PLANNING AMENDMENT

Application No. H23/0737/94/A1
Date Registered 29 NOV 1994
Case Officer

PLOT 5. OFF CHURCHGATE. WHAFCODE.

IMPEND GARAGE FOOT.

G. R. MERCHANT LEUNG AMICE, FIWO, ARCHITECTURAL, STRUCTURAL & LAND DRAINAGE CONSULTANT TEL: HOLBEACH (0408) 490800	
PROJECT: PLOT 5 OFF CHURCHGATE WHAPLODE	
CLIENT: DGM PROPERTIES LTD PODE HOLE SPALDING	
SCALES: 1/100	DATE: JULY 92
G. R. MERCHANT REVISIONS:	
DRAWING No.: DGM-W. 5A

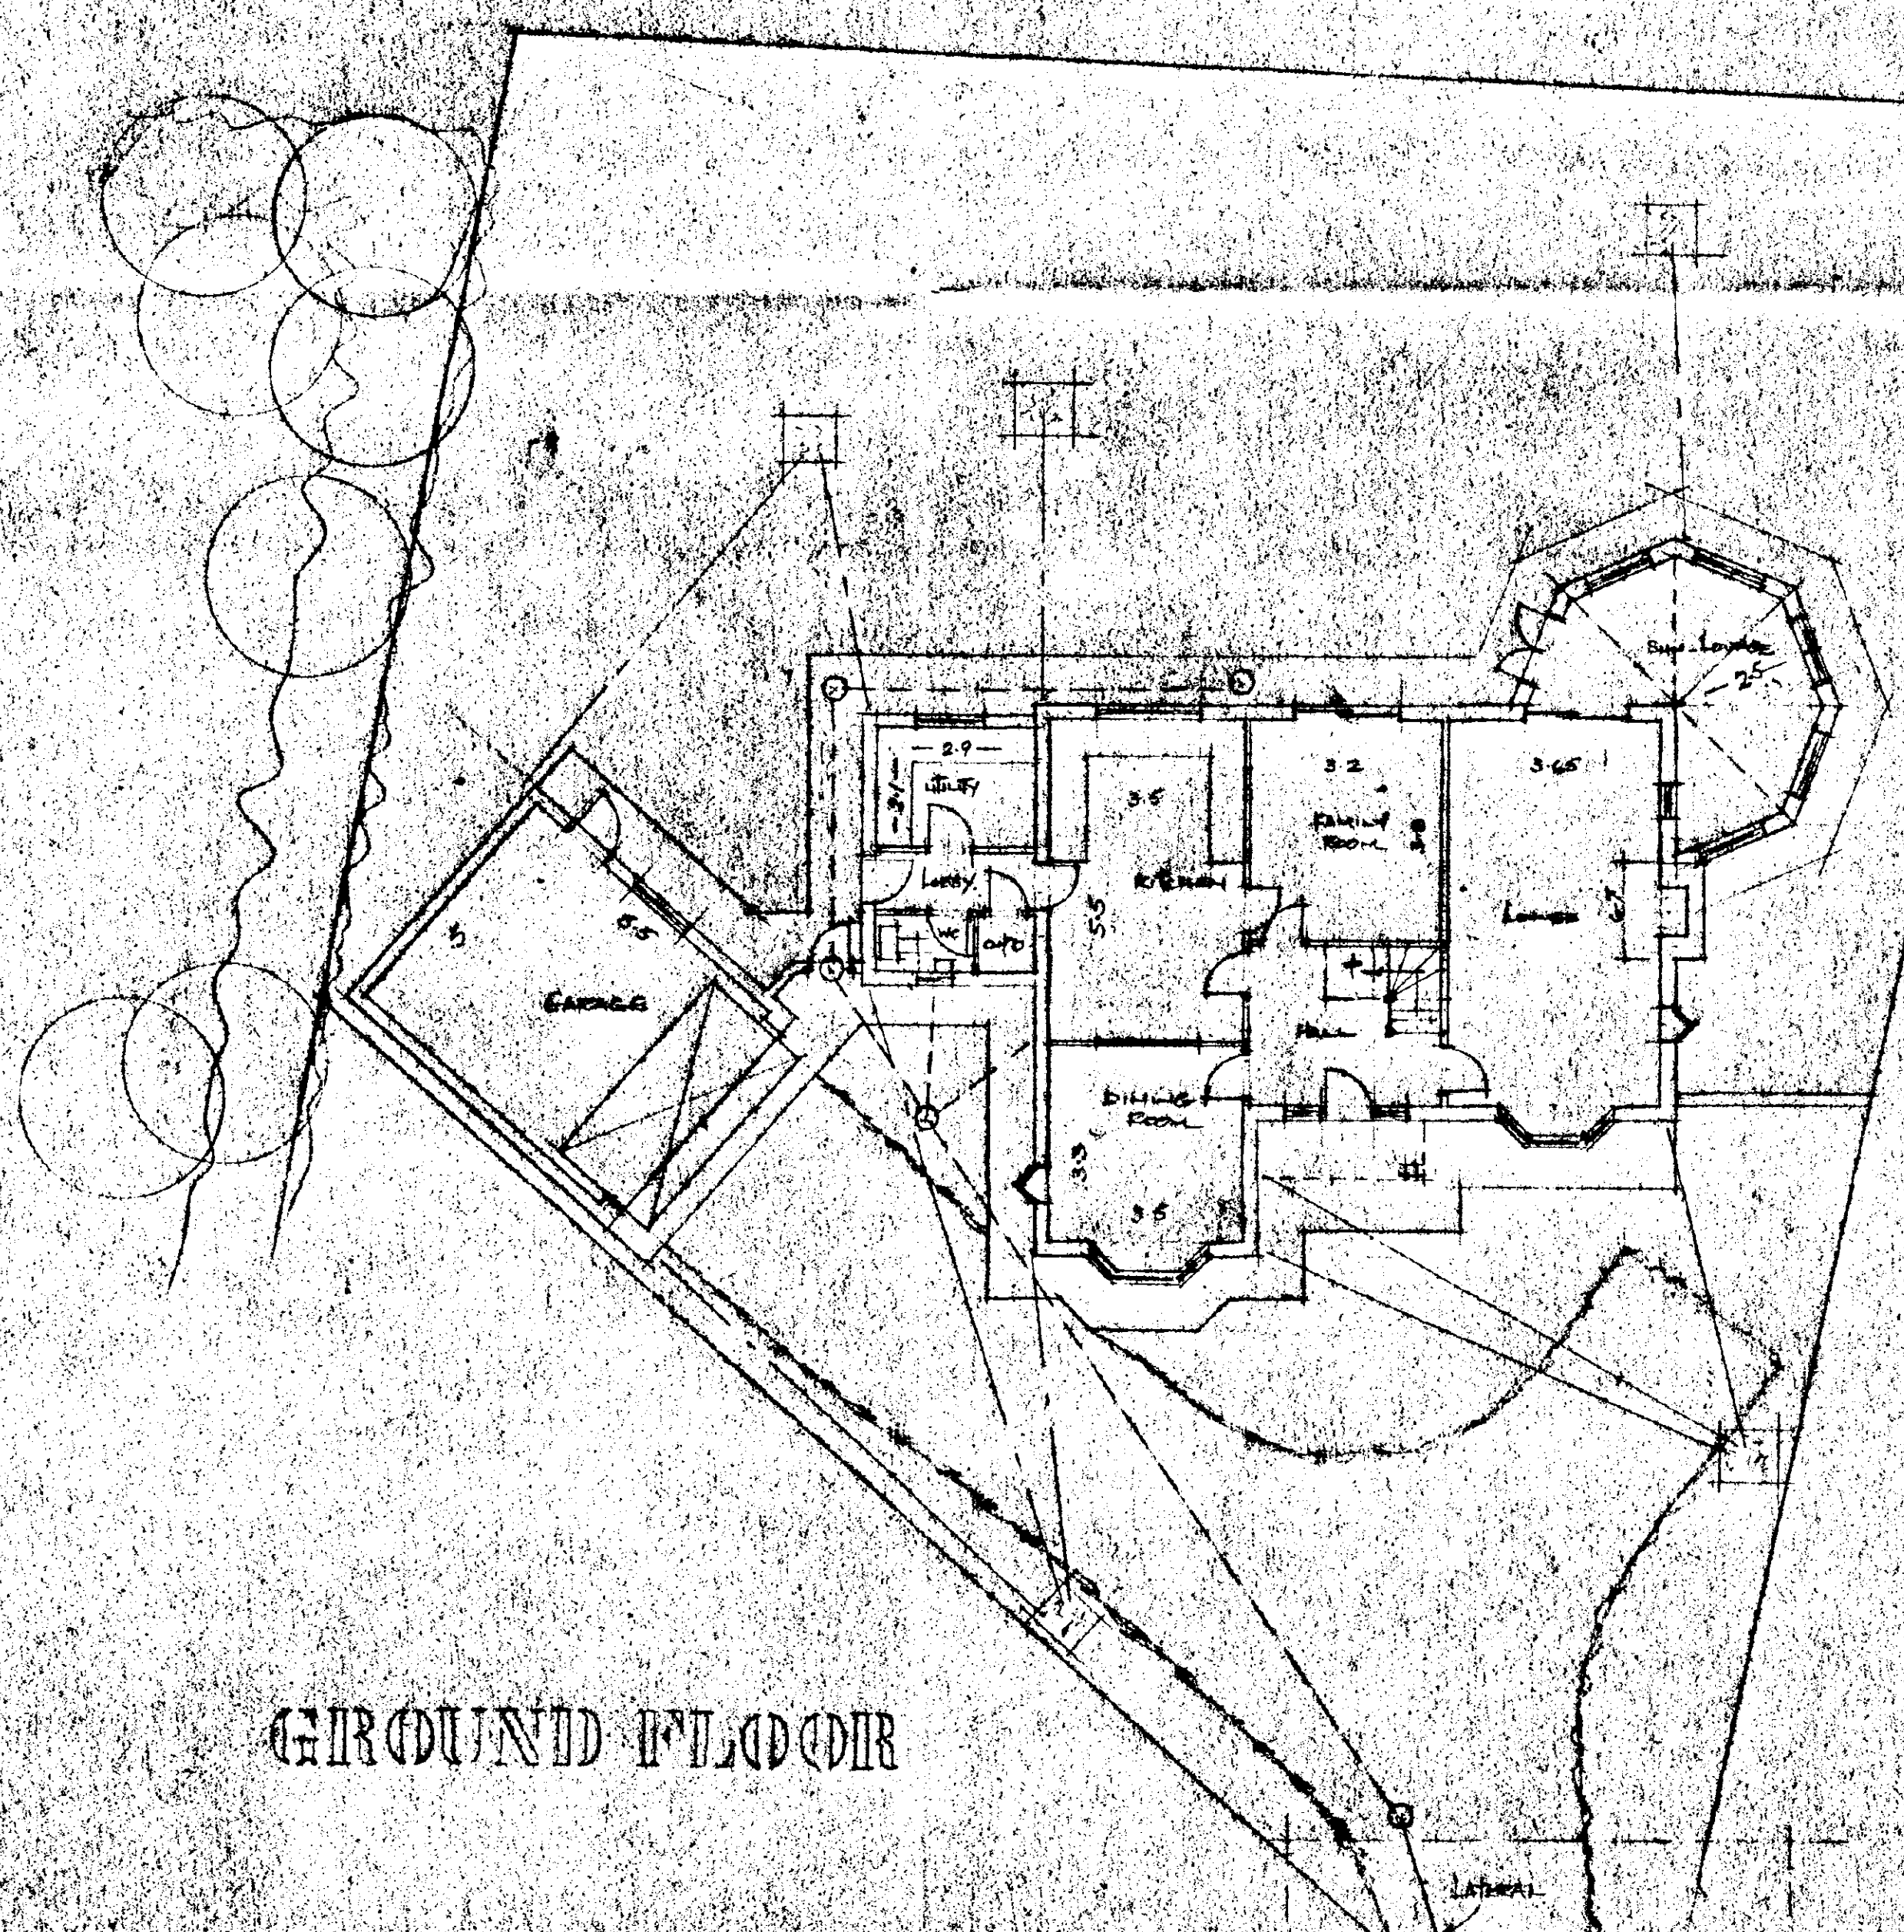
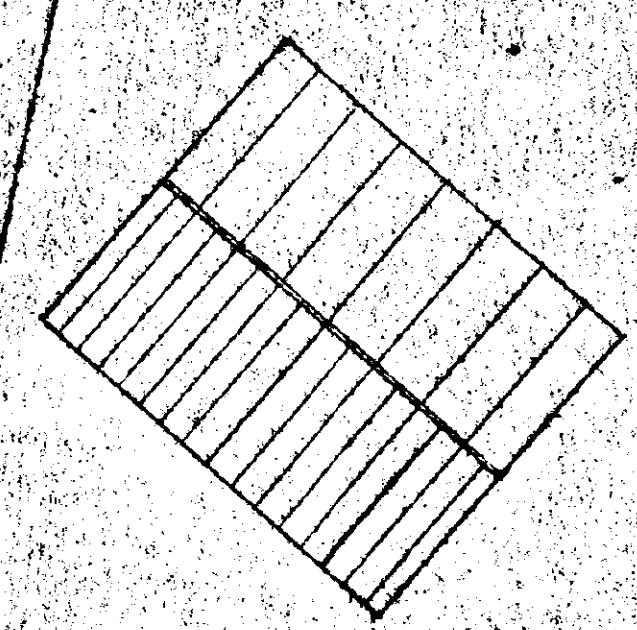
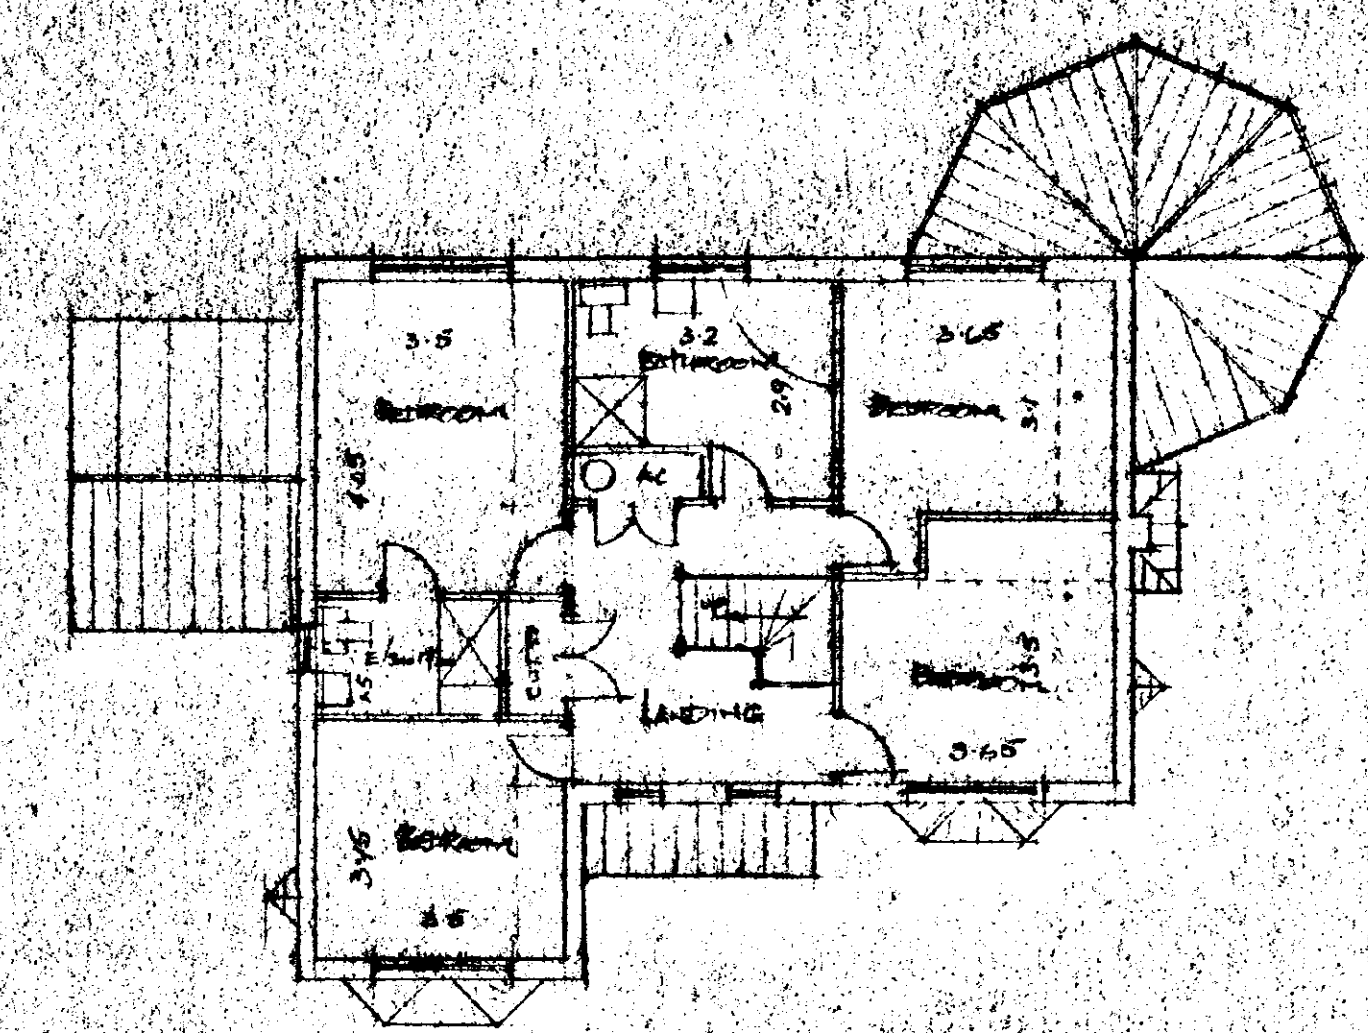
4 BETWEEN HOUSE & GARAGE
